Utah-Nevada Lane Variance, VA-24-4

Please accept the following comments from El Paso County Public Health (EPCPH) for the variance request referenced above:

#### Variance of Use Site Plan

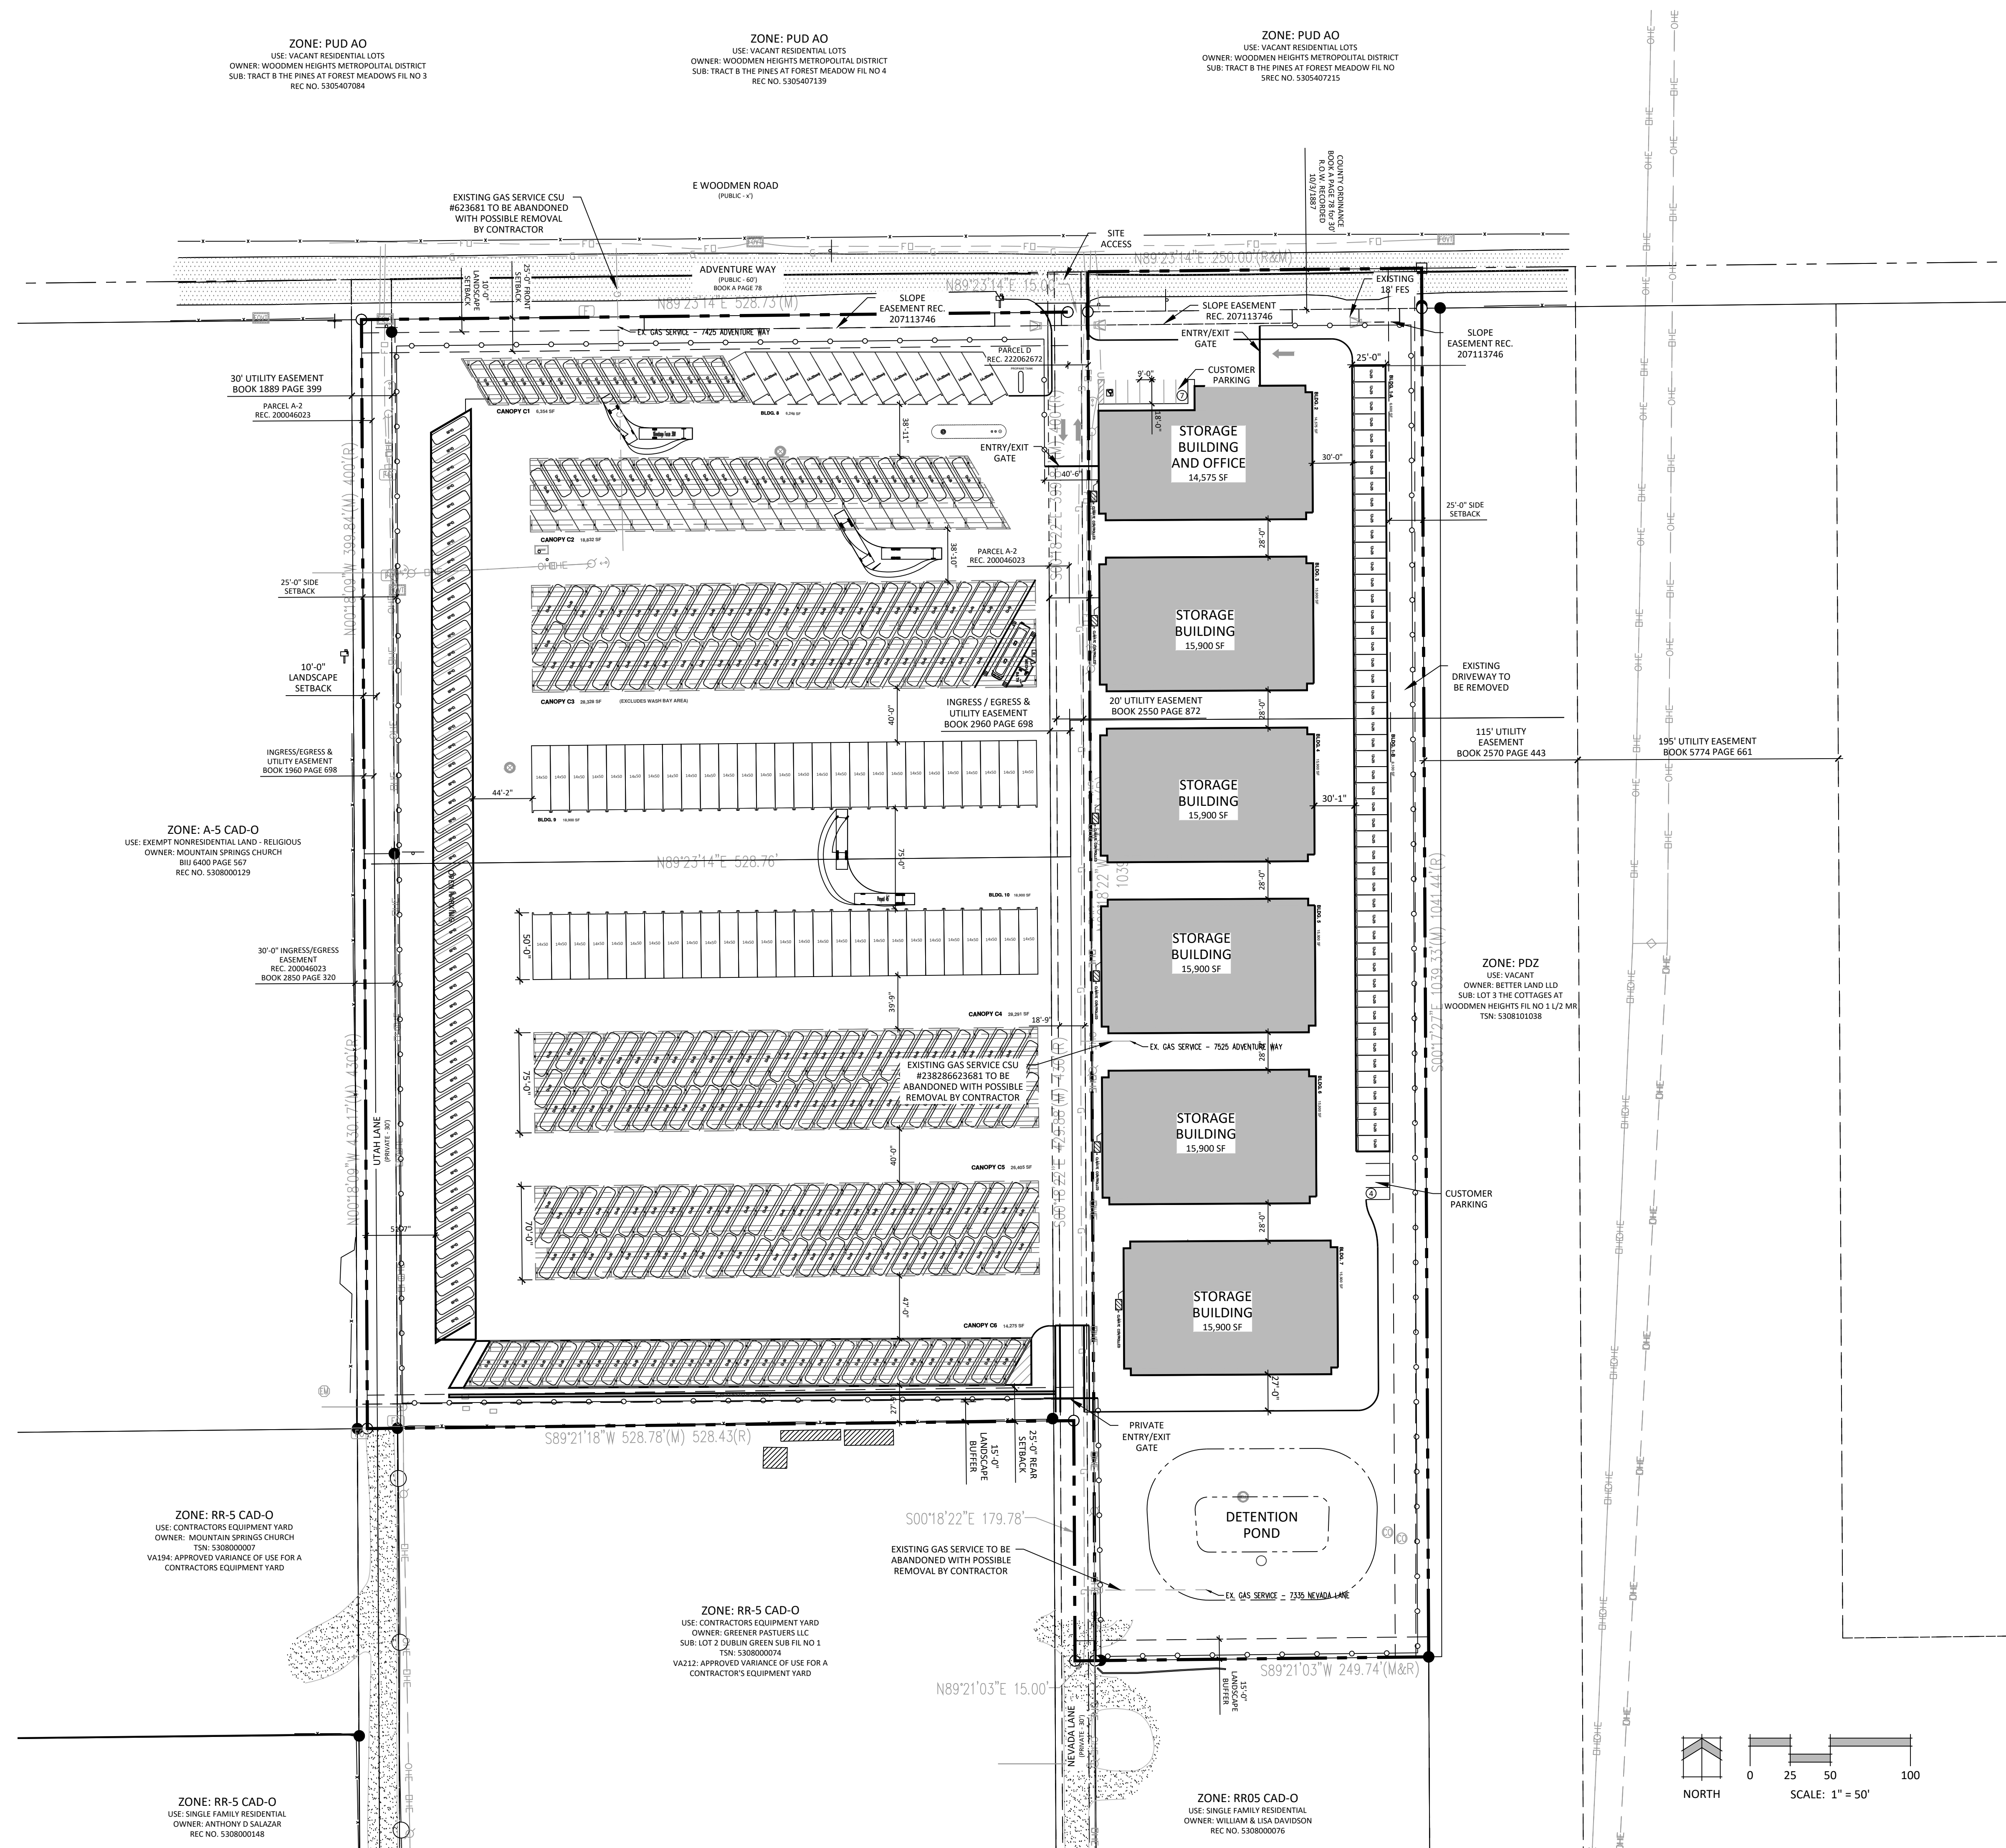
- **Water service for the proposed RV storage and mini warehouse facility is planned to be by an individual private well.**
- **Wastewater service for the proposed RV storage and mini warehouse is by an onsite wastewater treatment system (OWTS). The OWTS must be designed by a Colorado Registered Professional Engineer due to the commercial nature of the business. EPCPH indicates there is an approved 2010 OWTS on the site that serves an existing house. If this OWTS is to be used a Colorado Registered Professional Engineer must verify the adequacy of the OWTS. The house/office is not shown on the Site Plan Drawing, nor is the proposed OWTS and well. Please update the site plan to show the well and OWTS location as there doesn't appear to be much useful OWTS installation space.**
